# ORIEL WIND FARM PROJECT

## Environmental Impact Assessment Report - Addendum Chapter 5 Addendum: Project Description

MDR1520C  
EIAR – Chapter 5 Addendum  
A1 C01  
December 2025

Drawing file: Onshore cable drawings / B24 PE605-D027-094-001 TRANSITION JOINT BAY OPTION 2 AERIAL.pdf

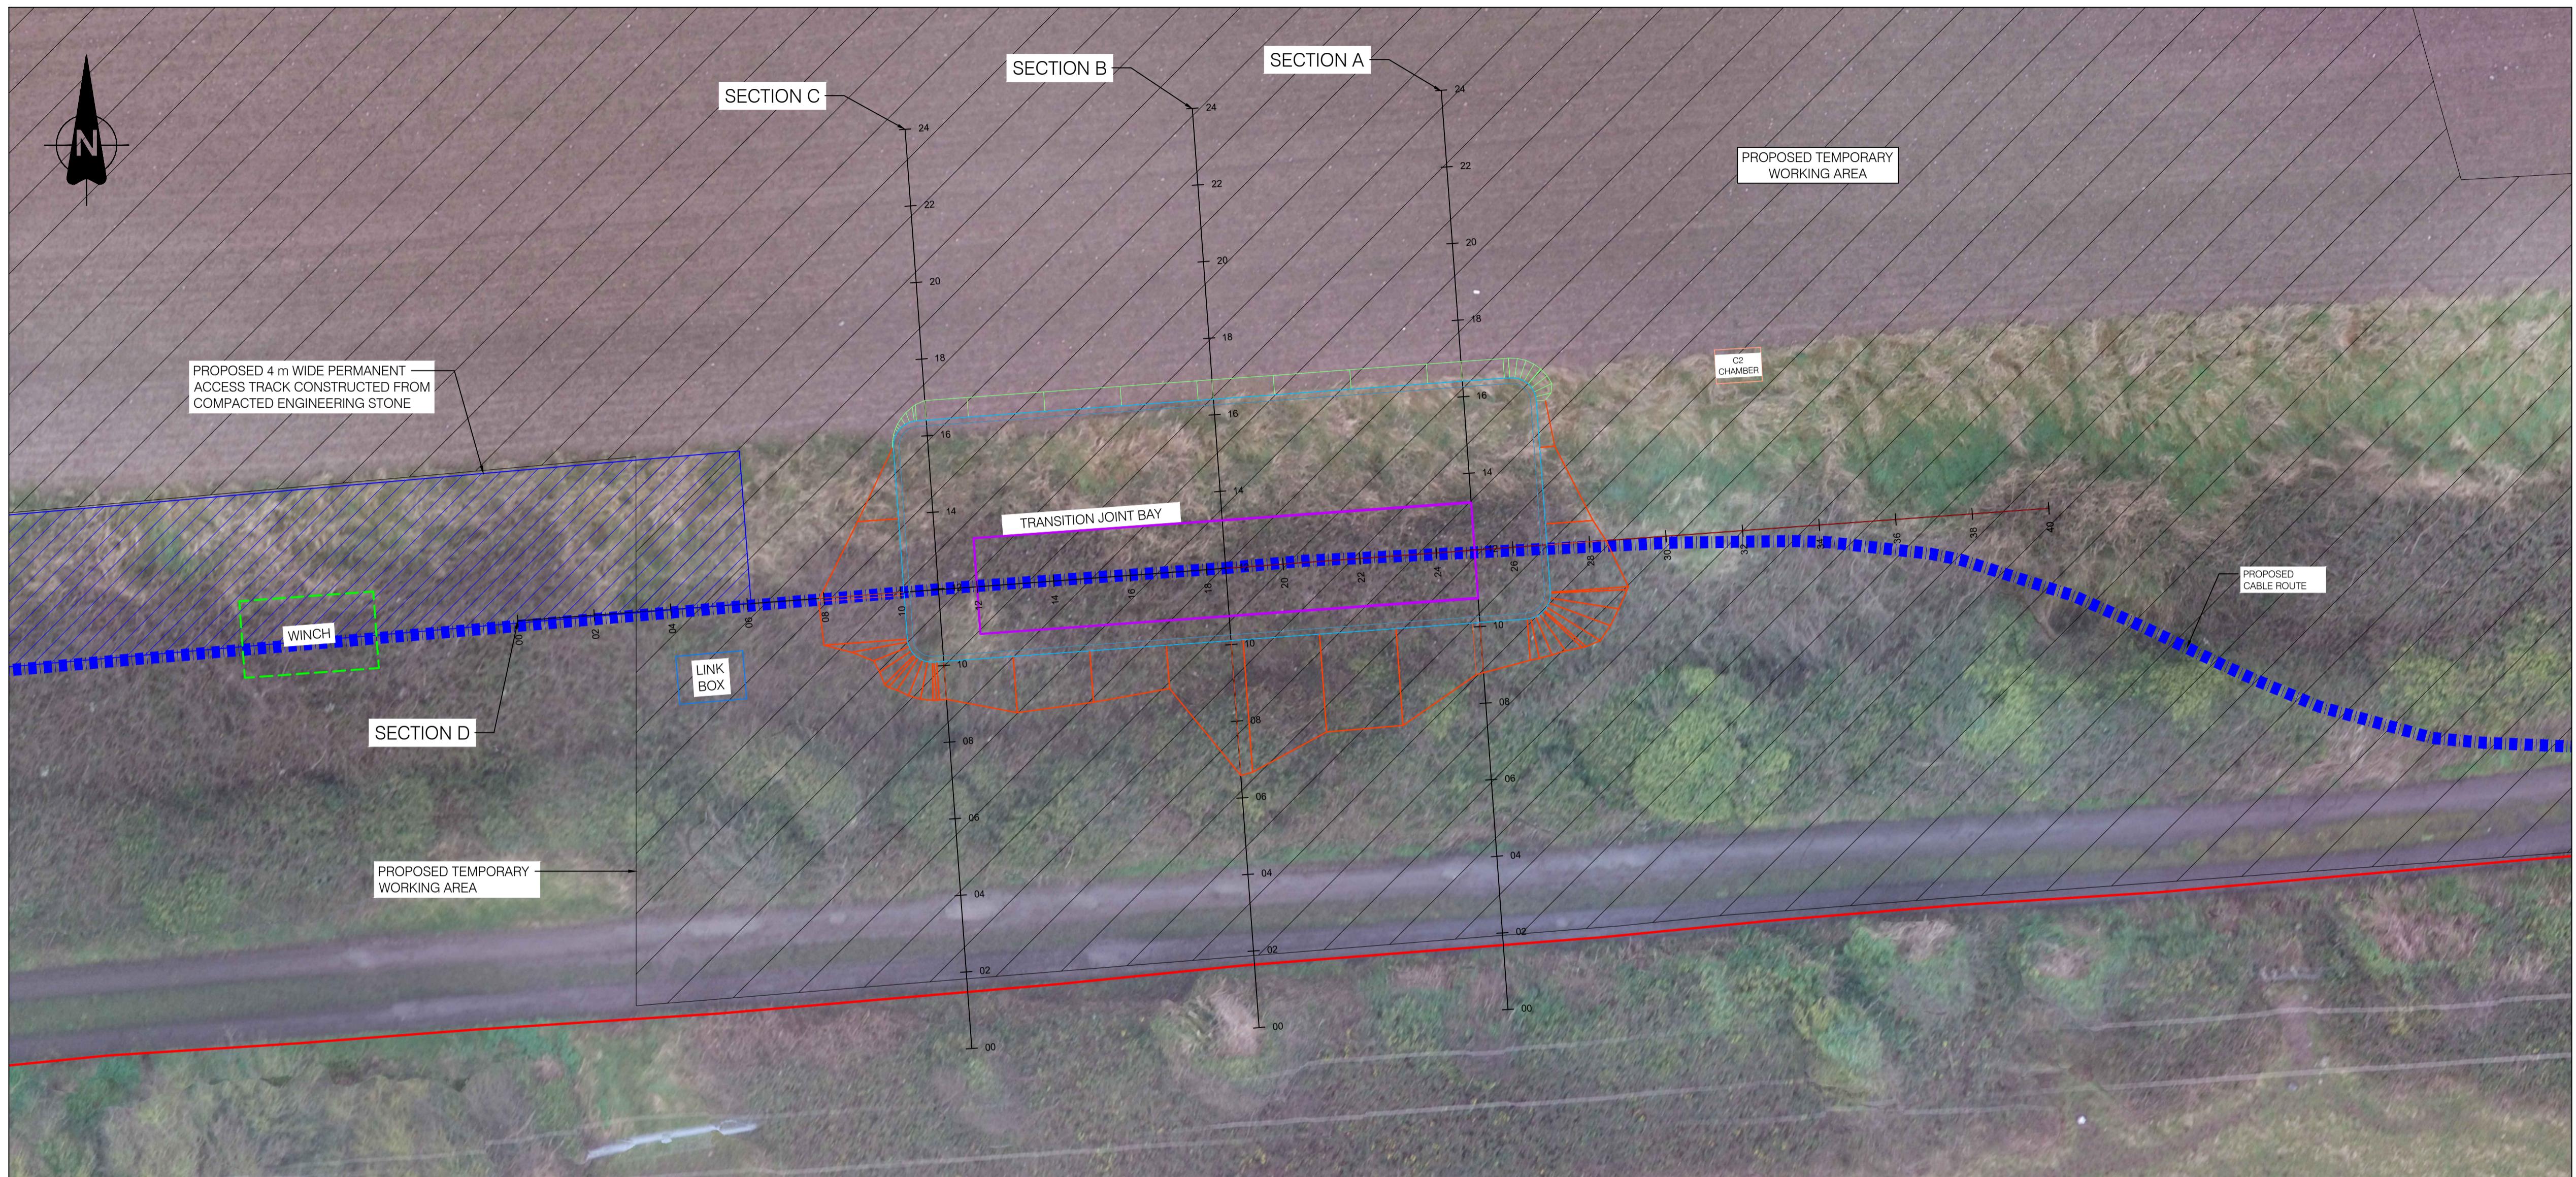
In response to the concerns raised by ACP in RFI 6.K, 8.G and 19.A, the Applicant has adjusted the proposed location of the TJB (options 1 and 2) and realigned the route of the export cable leading to the TJB (within the planning application boundary). A description of the adjustments is provided below and replaces the description provided in this section in chapter 5: Project Description (EIAR volume 2A).

In response to concerns raised in RFI 6.K, the two options for the location of the TJB have been adjusted and are presented on Map 12 of 12 in Figure 5A-16. The two adjusted options are described below.

- **Option 2** - As shown on Figure 5A-16 (map 12 of 12) the TJB option 2 is located in the field adjacent to Dunany beach at the southern boundary of Dunany Demesne. The offshore cable will be installed in a trench along approximately 120 m length of the laneway, before crossing the boundary wall of Dunany Demesne into the field. An approximate 10 m section of the boundary wall will be removed to facilitate the installation of the cable, but this will be reinstated after construction (see chapter 26 Addendum: Cultural Heritage (EIAR volume 2C Addendum)). The adjustment of the TJB location and realignment of the export cable route for option 2 is within the planning application boundary and ensures works will avoid impacts on the sedimentary cliff.

The EirGrid functional specifications require permanent vehicular access to the TJB. For this a single vehicle width access track along the southern boundary of the field will be constructed (if option 2 is used). The permanent access track is shortened in length as a result of the repositioned TJB (see Figure 5A-16, map 12 of 12). The existing public access lane will be used if TJB option 1 is constructed.
